Recommendation Report for Planning Permission for Works or Extension to a Dwelling**REF NO:** EP/98/15/HH**LOCATION:** 34 Tamarisk Way
East Preston**PROPOSAL:** New first floor balconies to south elevation.
& extension to the first floor north elevation (resubmission following EP/59/15/HH).**SITE AND SURROUNDINGS**

South Elevation	Elev	1:100
-----------------	------	-------

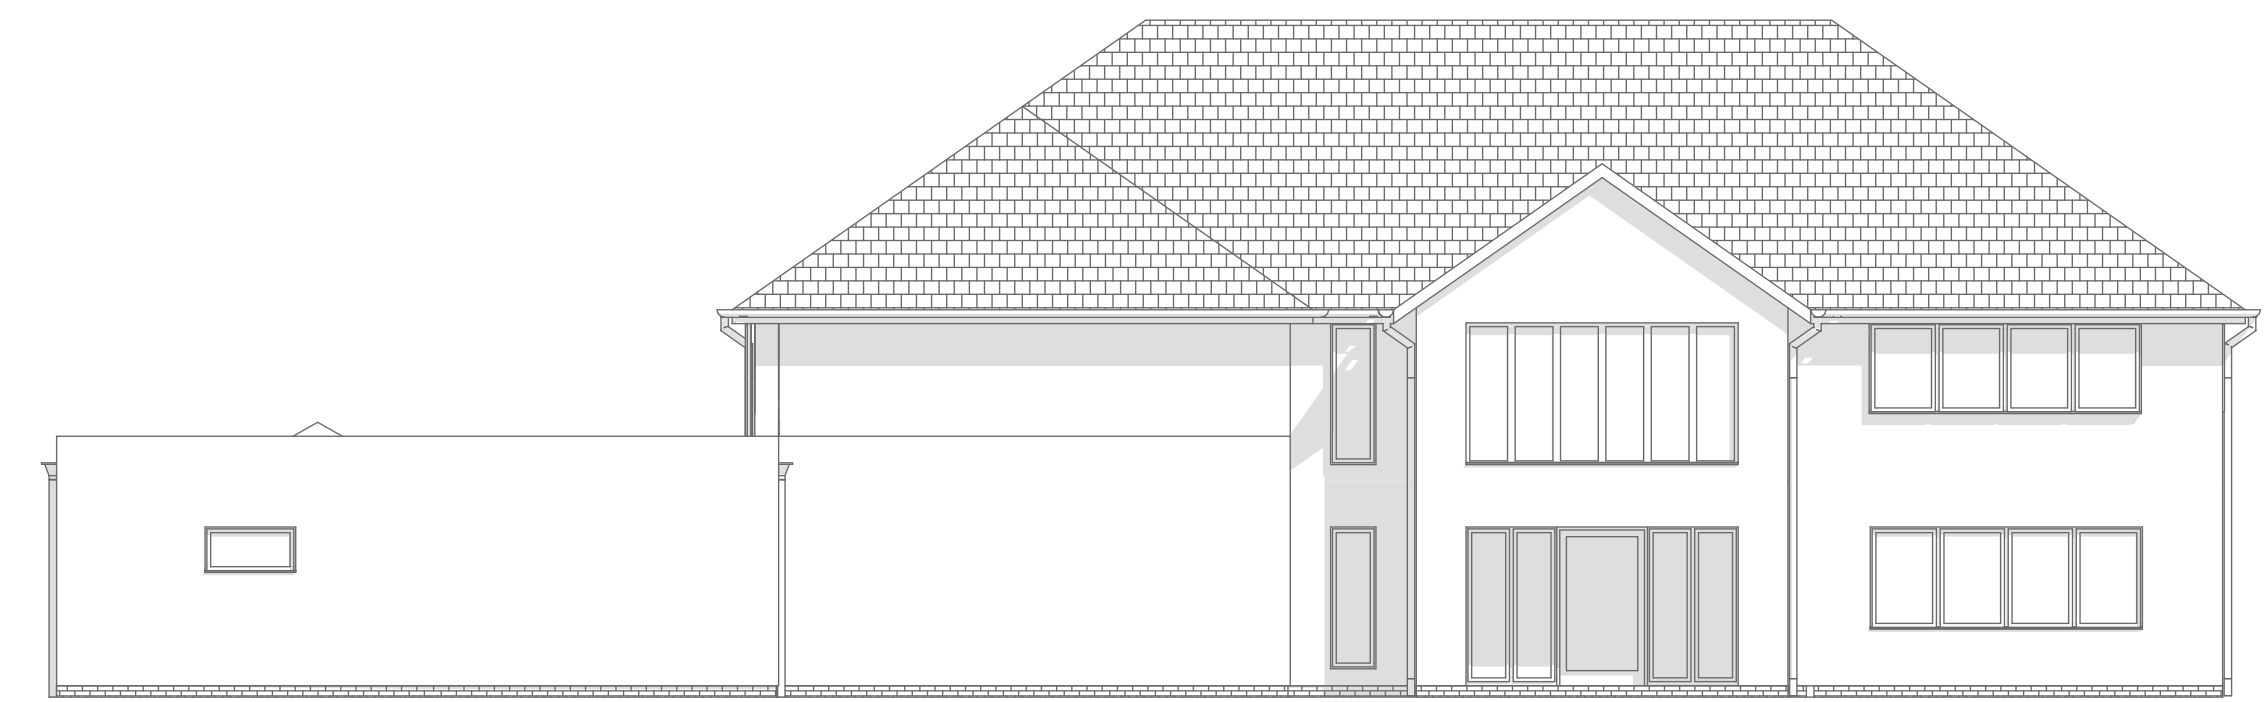
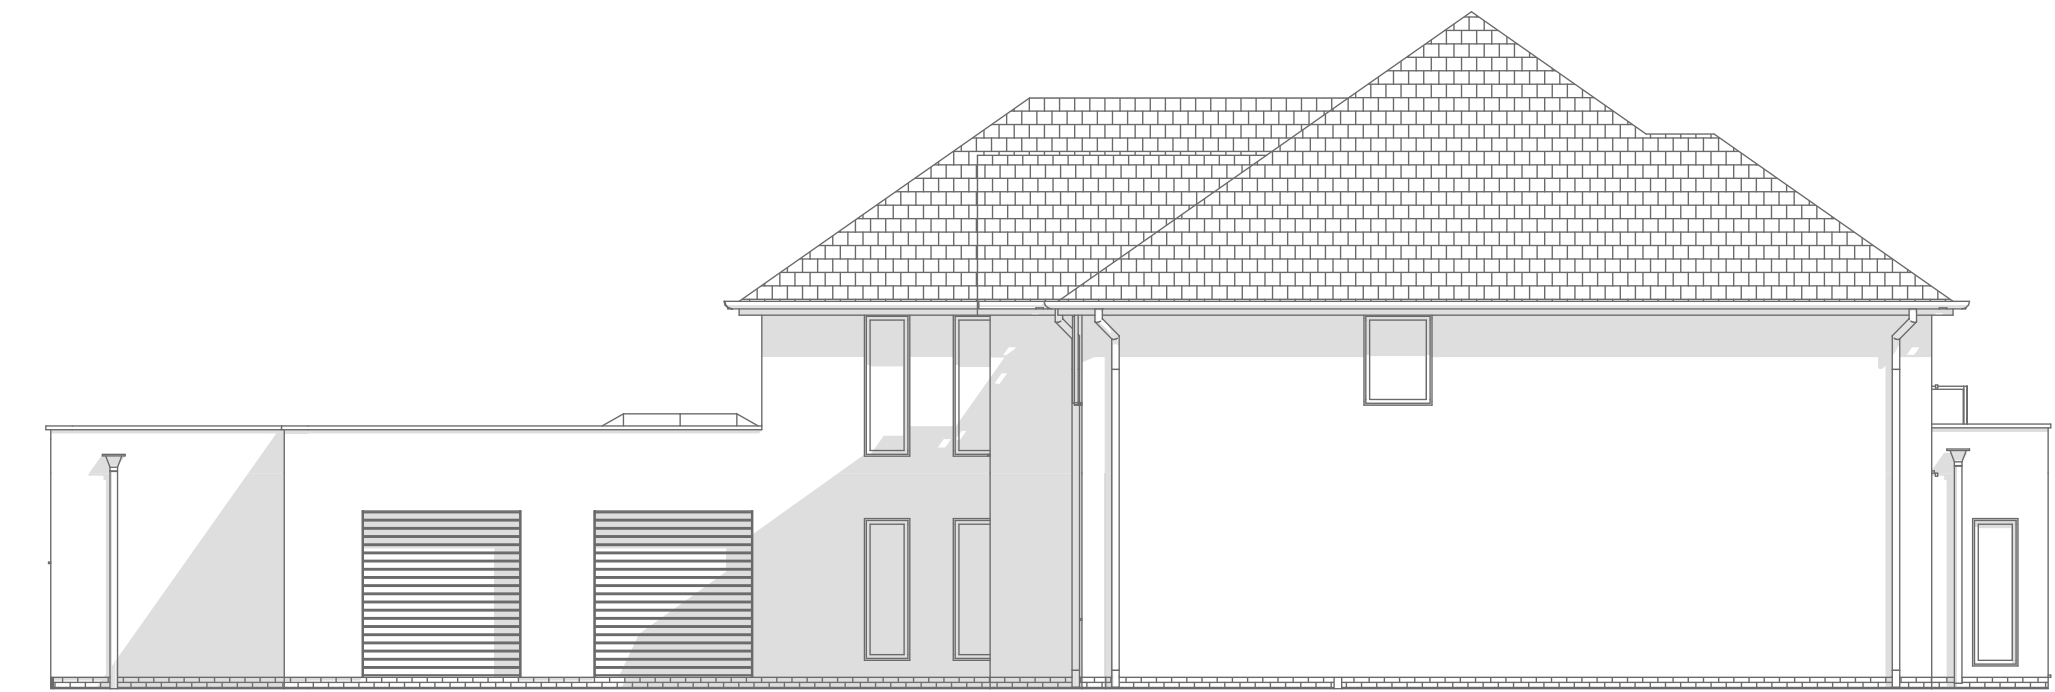
The proposed balconies at first floor level on the southern elevation of the building are not considered to adversely impact upon the appearance or character of the dwelling due to their design. Therefore, the proposed balconies are considered to be in accordance with policies GEN7 (ii) and DEV19 (i) & (ii) of the Arun District Local Plan.

The proposed balconies will be located on the primary elevation of the property and will be situated forward of the primary elevations of neighbouring properties. Therefore it is considered that the proposal will not give rise to overlooking of any private amenity space and as such the proposal is considered to be in accordance with policies GEN7 (iv) and DEV19 (iii) of the Arun District Local Plan.

1. First Floor 1:100

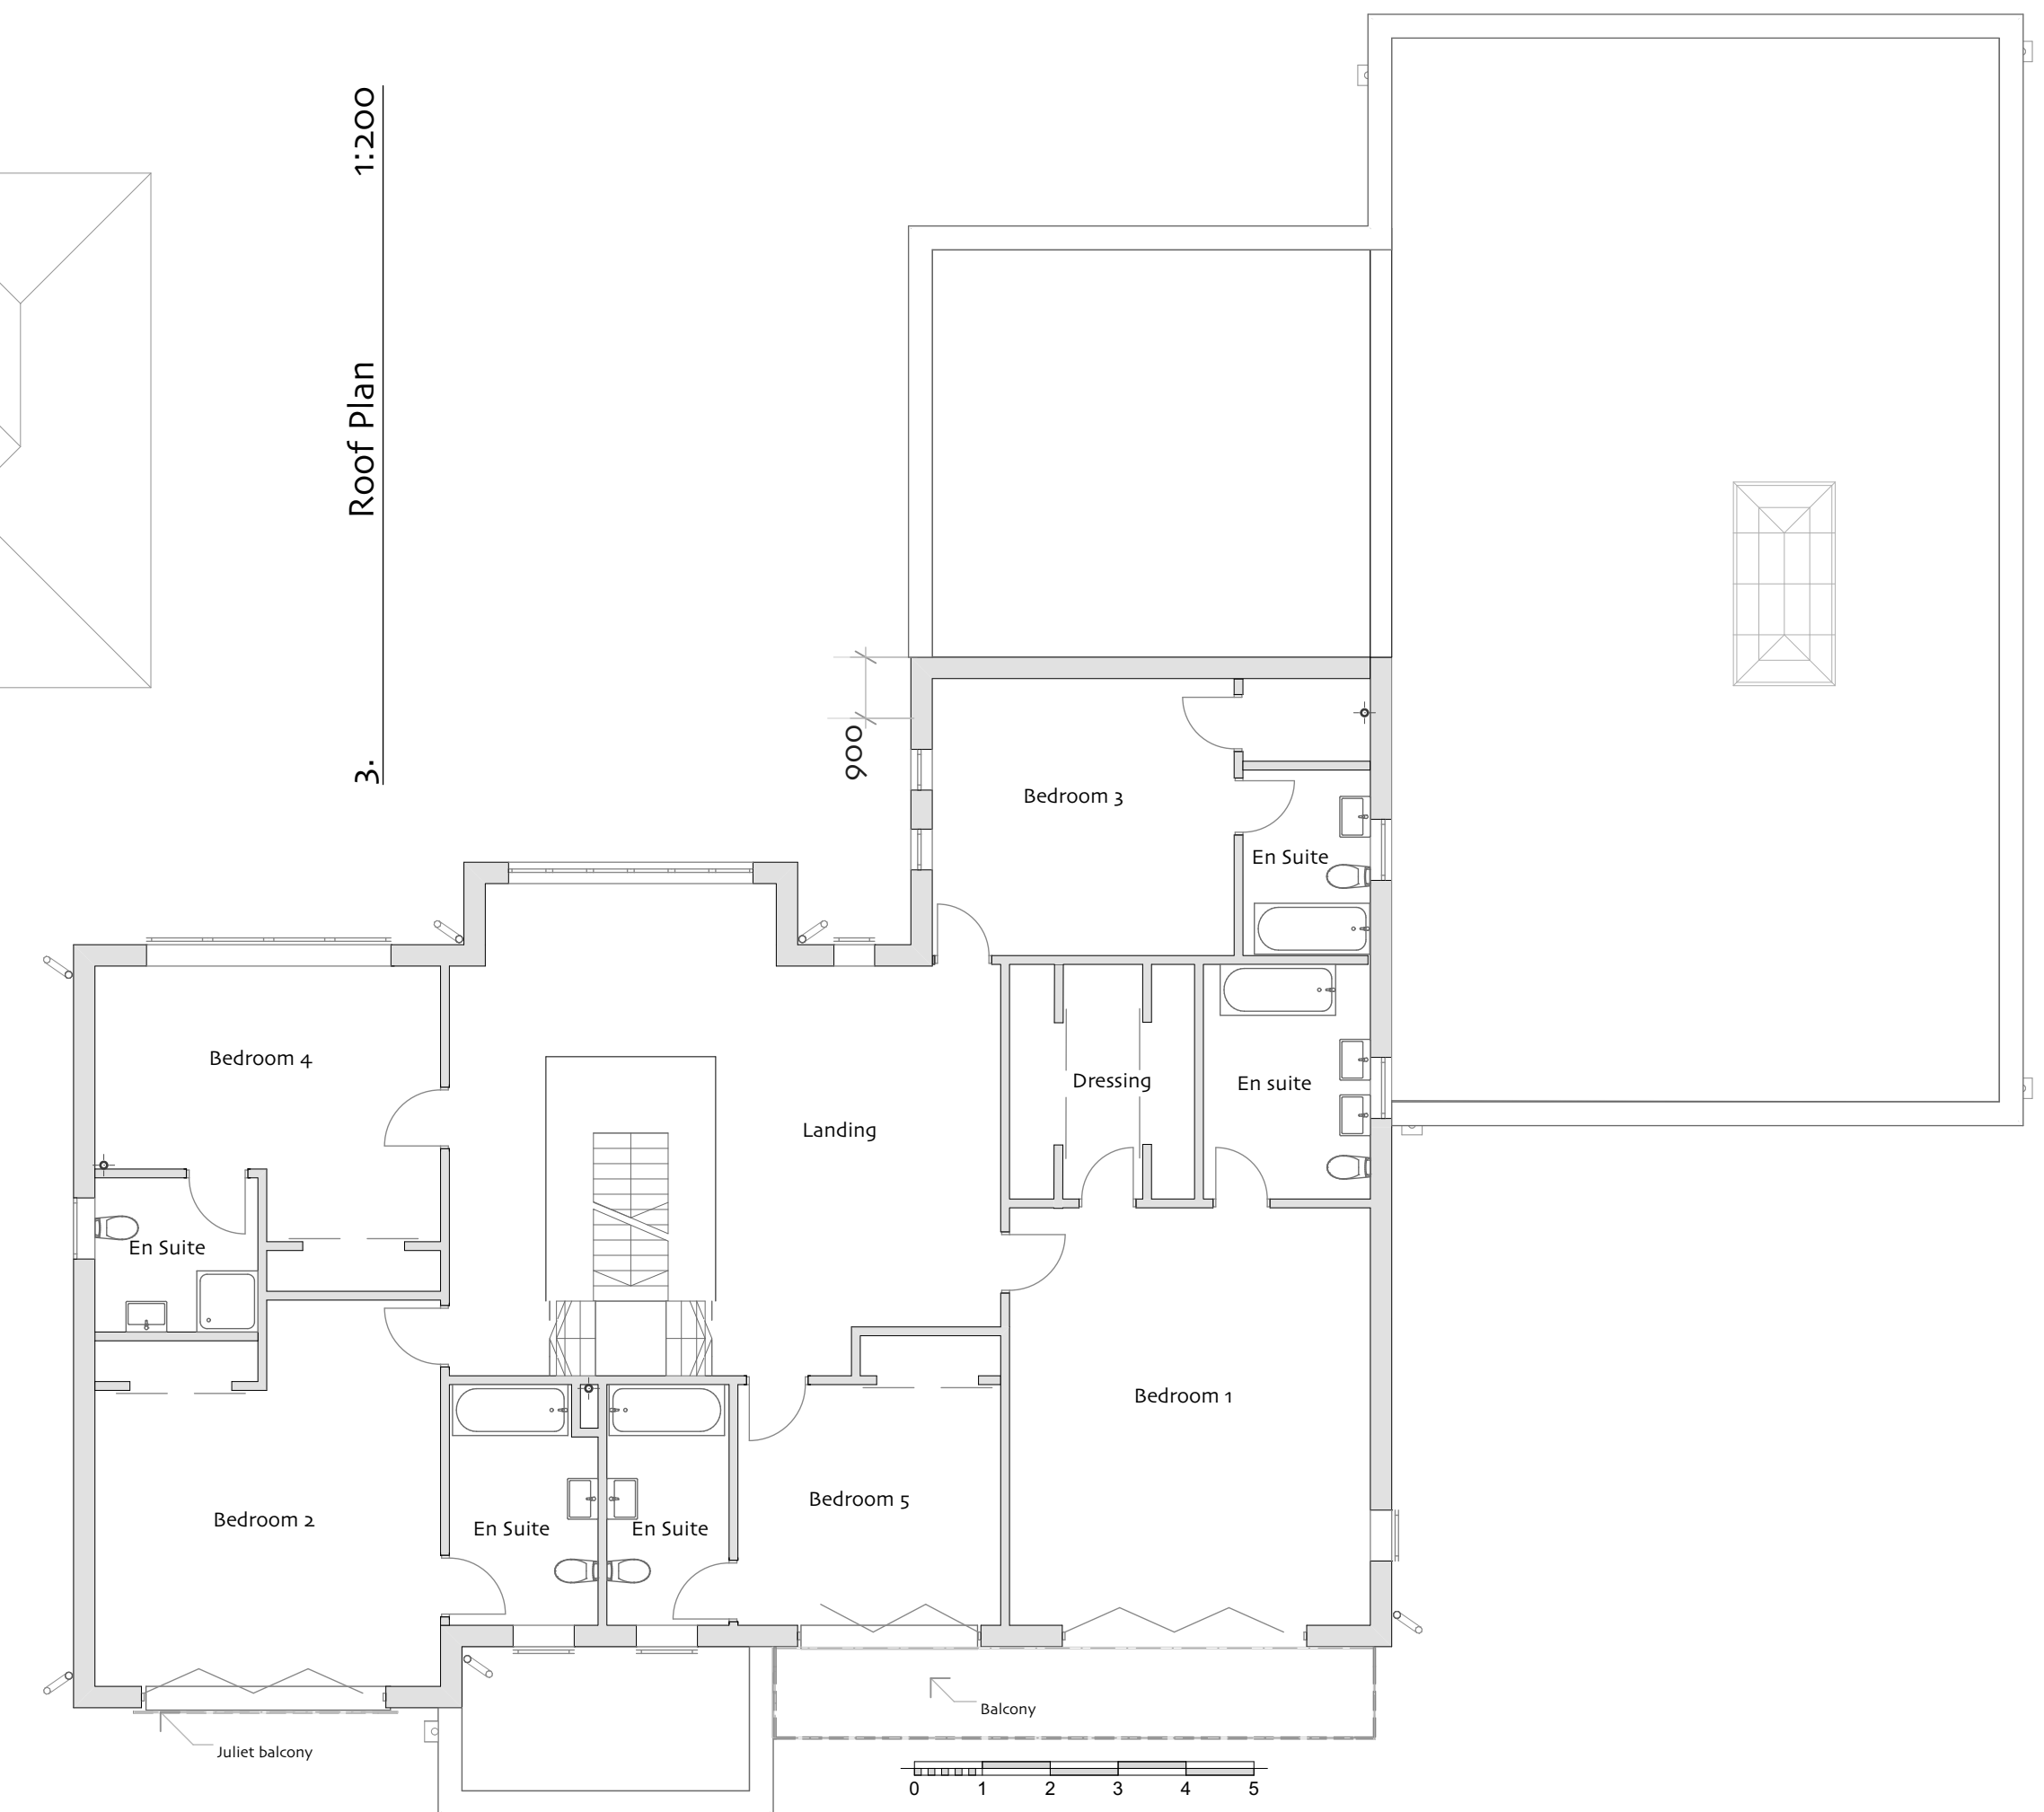
The 0.9m first floor extension will not adversely impact upon the character and appearance of the dwelling as approved under reference EP/16/15/HH and constitutes a relatively minor addition to the original approval. Therefore, the proposed extension is considered subservient and well integrated with the host dwelling in accordance with policies GEN7 (ii) and DEV19 (i) & (ii) of the Arun District Local Plan.

The proposed extension at first floor level, given its design, location and size is not considered to give rise to any overbearing, overshadowing or overlooking impacts and is therefore deemed to be in accordance with policies GEN7 (iv) and DEV19 (iii) of the Arun District Local Plan.
